Subject: Eagle Rising SP205 Preliminary Plan Reinstatement

Submittal Name:		EDARP Review Comments											
Project Name:		SP205 - Eagle Rising Preliminary Plan Reconsideration											
		September 7, 2023 submittal

STREAM VEGETATION  
PHOTO LOCATIONS

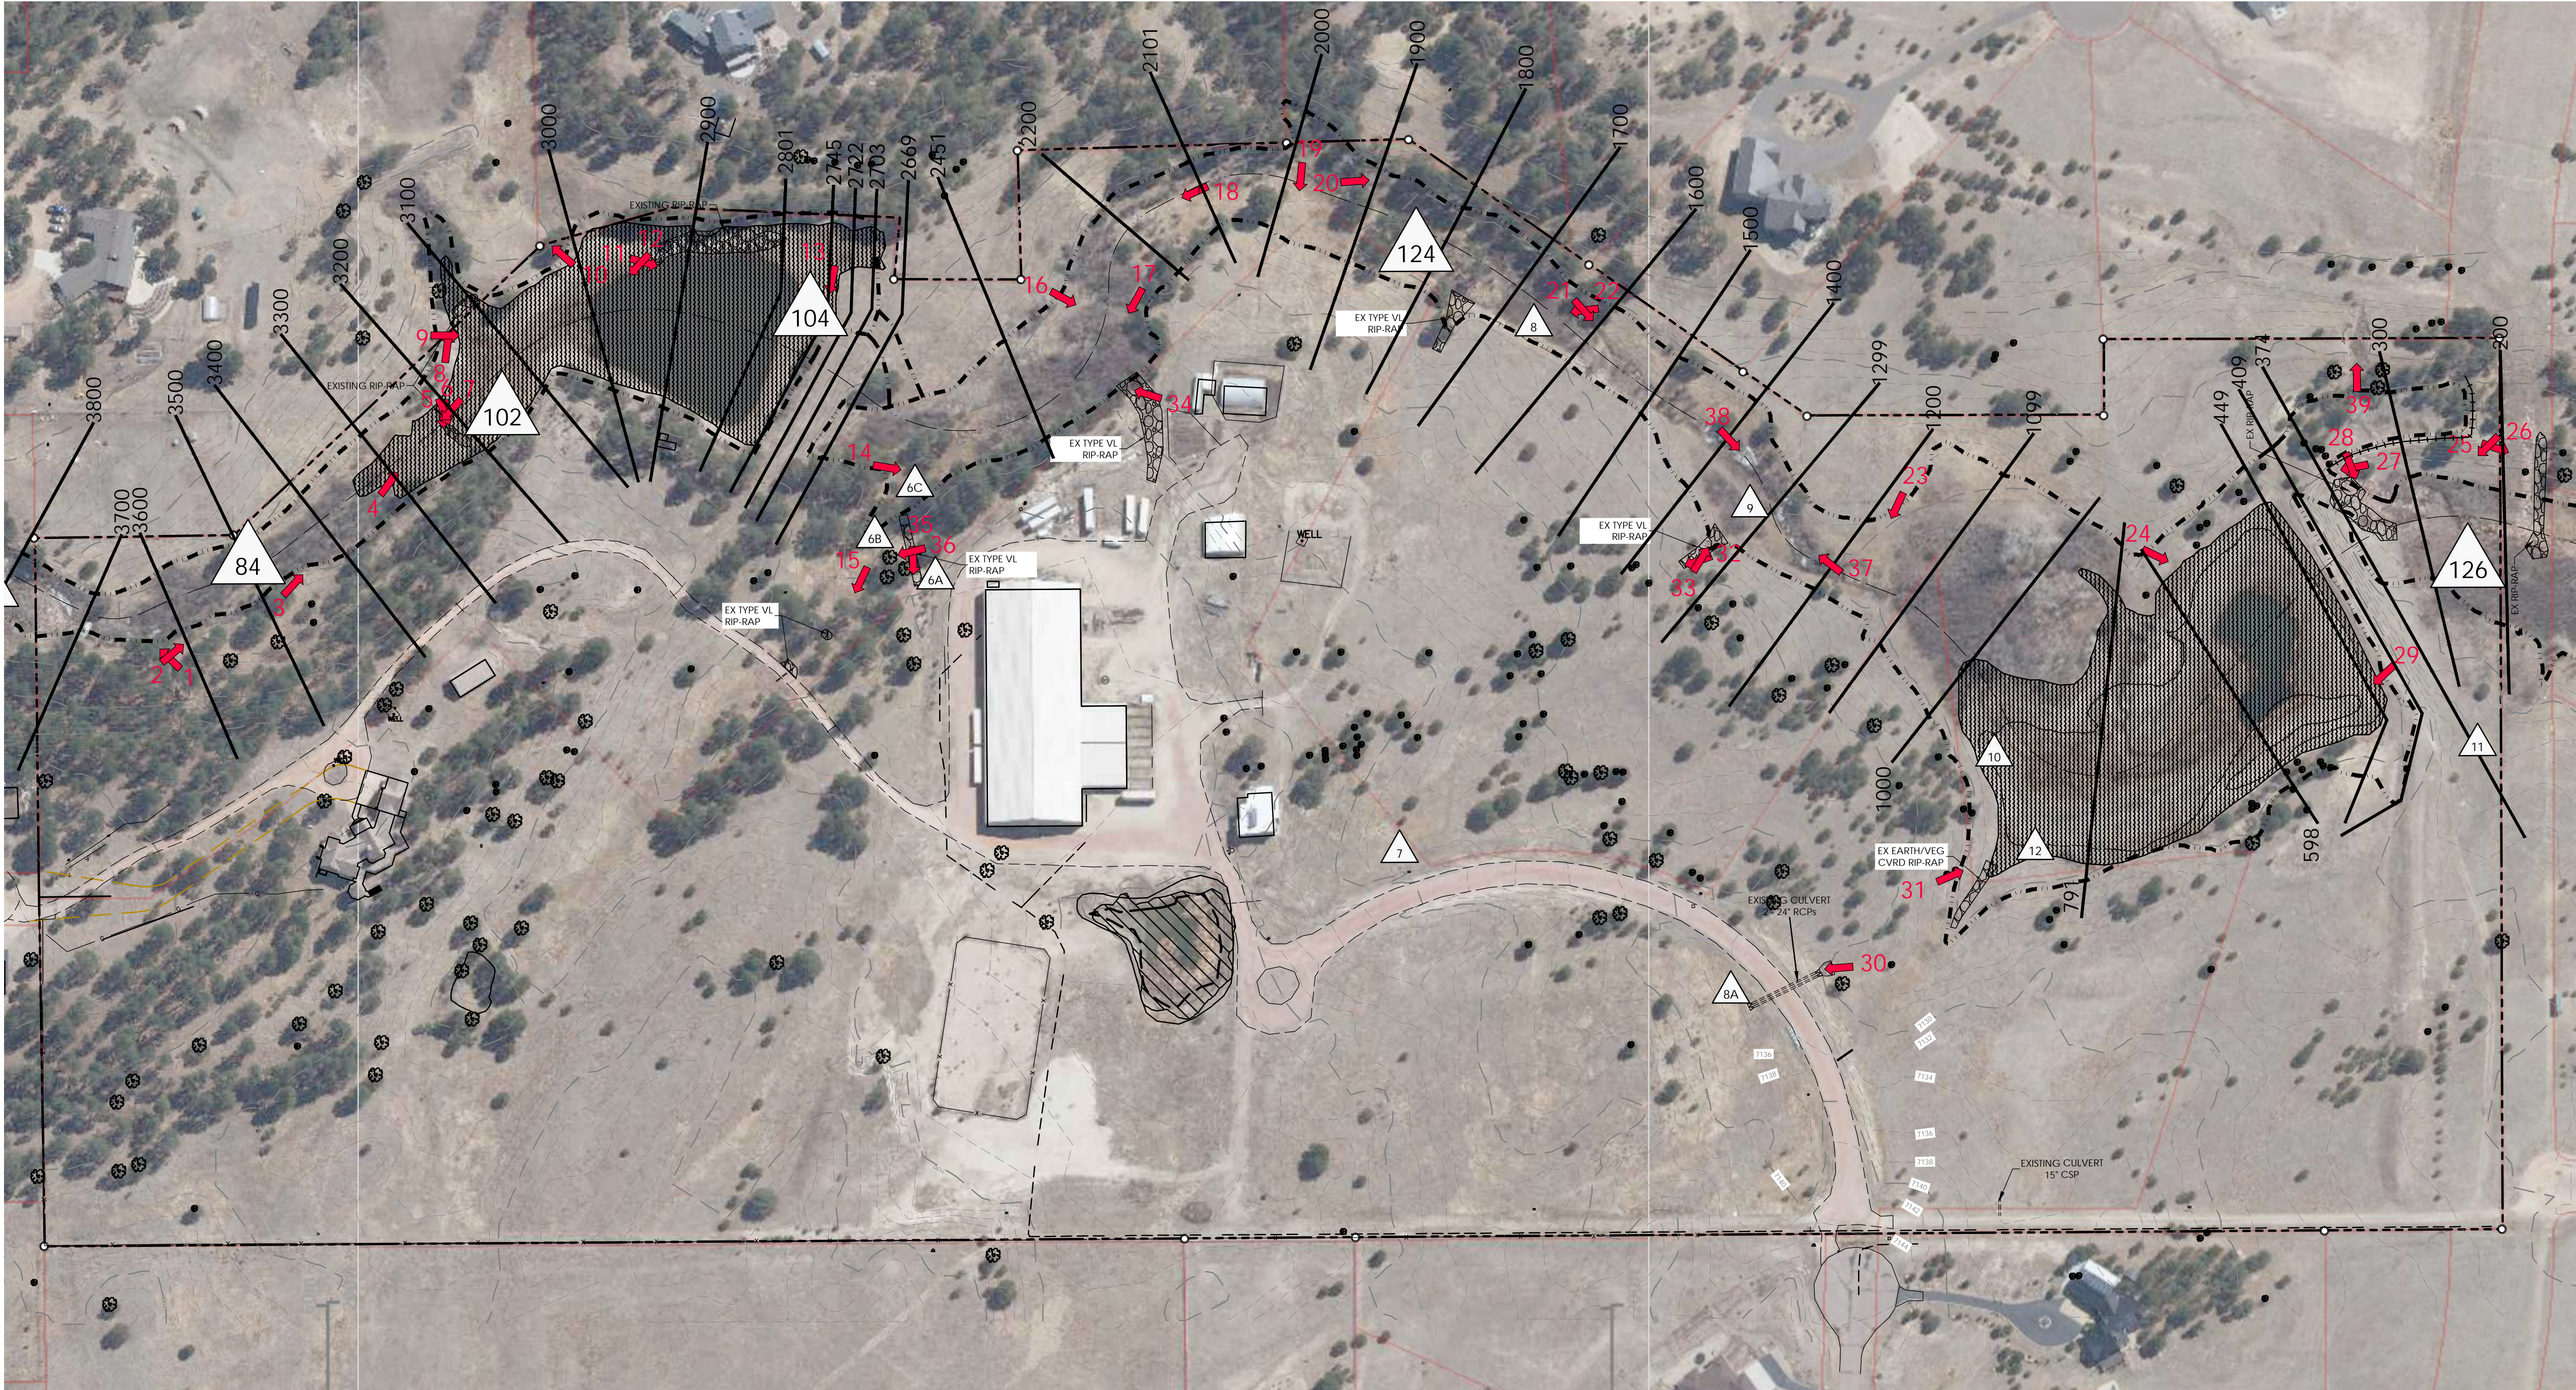
24	Master Development Drainage Plan / Preliminary Drainage Report	PCD Engineering Division	Yes	Jeff Rice	9/29/2023 16:00	(MDDP/PDR redlines)	187	Purple lines are parallel to areas of the channel Staff would like pictures of or site visit to see	C - Disapproved	11/3/2023	Eagle Rising Master Development Drainage Plan / Preliminary Drainage Report Nov 2, 2023	multiple	See Photo #3 and #4 for Design Point 84 See Photo #16 and #17 for Design Point 104 See Photo #18, #19, and #20 for Design Point 124 See Photo #25 and #26 for Design Point 126  See pictures provided in ERO Natural Resources Assessment Eagle Rising Subdivision  Meeting Resolution and recorded with Meeting Notes on 10/25/23 with El Paso County Staff was Reolved with: "Preliminary Drainage Report / Plans: Channel stabilization, maintenance access. Site visit by Palmer and LaForce, (excluding Rice), with Development Team members. Noted that the Eagle Rising Development will not add to the stormwater flow in the creek. Gorman to research to provide information to support that the existing well established willow vegetation can withstand 5 fps velocity. Then prepare a deviation request."

CREEK ACCESS

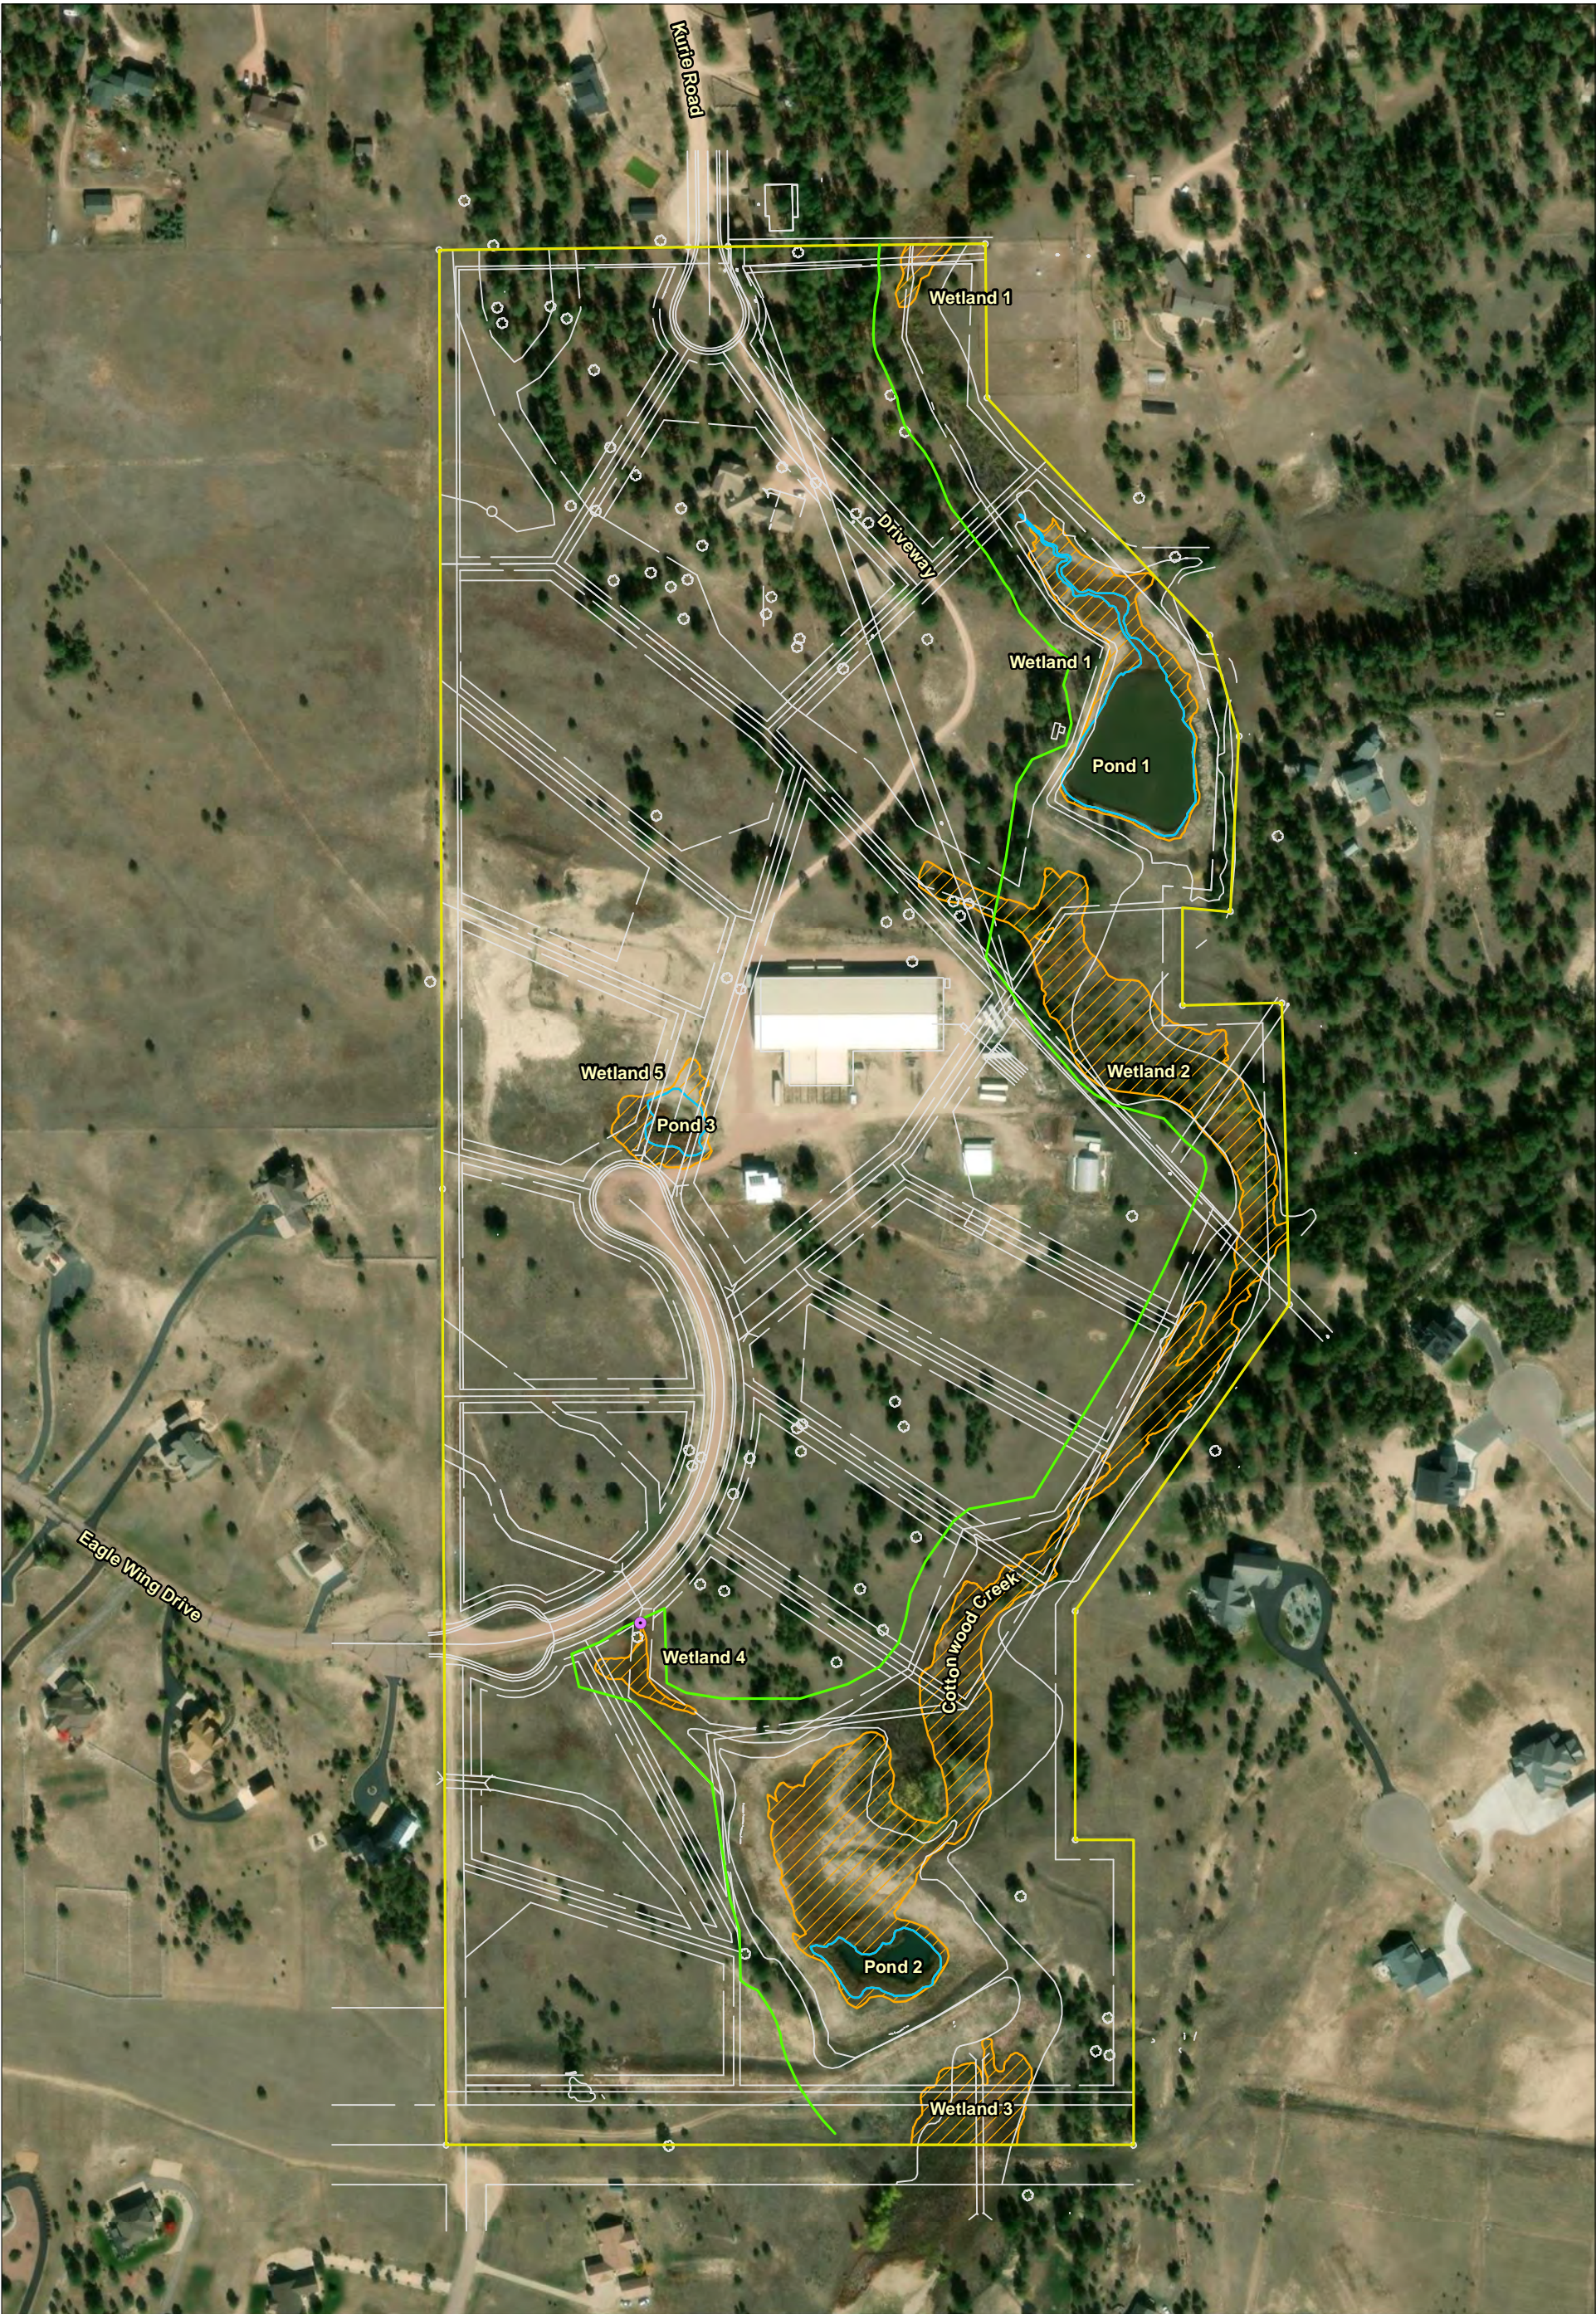
8	N/A	PCD Engineering Division	Yes	Jeff Rice	9/29/2023 15:58	Memorandum SP-20-005 – Eagle Rising Fourth Submittal (2022/2023 third review)	2	Preliminary Drainage Report / Drainage Plans 7.Discuss maintenance access provisions (for channels and BMPs), maintenance requirements and responsibility, and the Private BMP Maintenance Agreement and Easement that will be provided for the channel and any required PBMPs. Per criteria, a 15 foot wide access easement and an all-weather access road is required on each side of the main channel. Unresolved. Unresolved.	E - Answer provided	11/3/2023	Eagle Rising Master Development Drainage Plan / Preliminary Drainage Report Nov 2, 2023		Drainage Criteria Manual County of El Paso 2018 2.2.2 Channelization "A stable natural channel reaches "equilibrium" over many years. Therefore, channel modifications should be minimal"  The No-build Area/ Drainage Easement being provided for the creek coupled with the Drainage Easements provided at every lot line provide adequate access for the creek and pond areas. The pond embankments provide access to the east side of the creek. Additionally, maintenance will be performed as need by the HOA and will not be a county obligation or concern.  The creek has been stable for over 12+ years through 100 and 500/1,000 year storm cycles.  Meeting Resolution and recorded with Meeting Notes on 10/25/23 with El Paso County Staff was Reolved with: "Preliminary Drainage Report / Plans: Channel stabilization, maintenance access. Site visit by Palmer and LaForce, (excluding Rice), with Development Team members. Noted that the Eagle Rising Development will not add to the stormwater flow in the creek. Gorman to research to provide information to support that the existing well established willow vegetation can withstand 5 fps velocity. Then prepare a deviation request."
